**Consultation Response from KC,  
Lead Local Flood Authority**

**2024/91242 Land north east of, Shepley Road, Stocksmoor, Huddersfield, HD4 6XW**

**Erection of residential development (up to 50 dwellings) with associated access, parking,  
public open space, landscaping and infrastructure**

**Date Responded: 12/06/2024.**

Figure 2. Watercourse Location

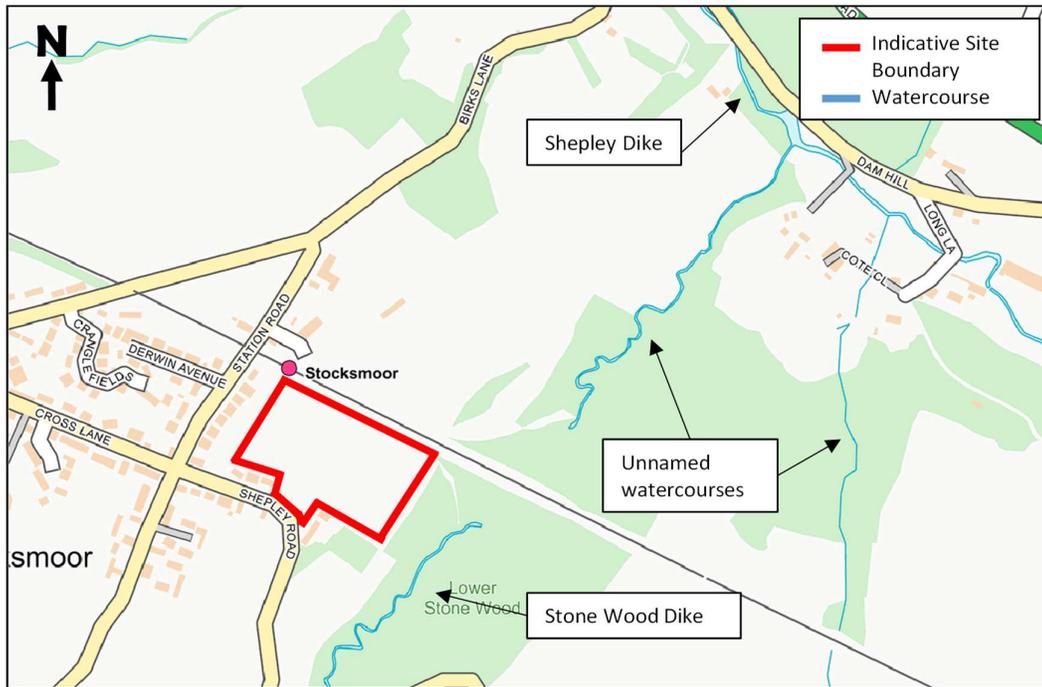
The submitted FRA contains an Outline Drainage Strategy. The LLFA agrees that as the site is located within FZ1, a sequential test is not required and the Flood Risk Impacts are low. In addition, the LLFA considers infiltration into the underlying soil as not being feasible due to the steeply sloping ground to the east of the development and the risk of re-emergence of flows that could de-stabilise the slope. Therefore, the LLFA accepts the proposal to discharge attenuated surface water flows to a local unnamed watercourse to the east of the site (a tributary of Stone Wood Dike) as shown on the plan in Appendix B of the FRA.
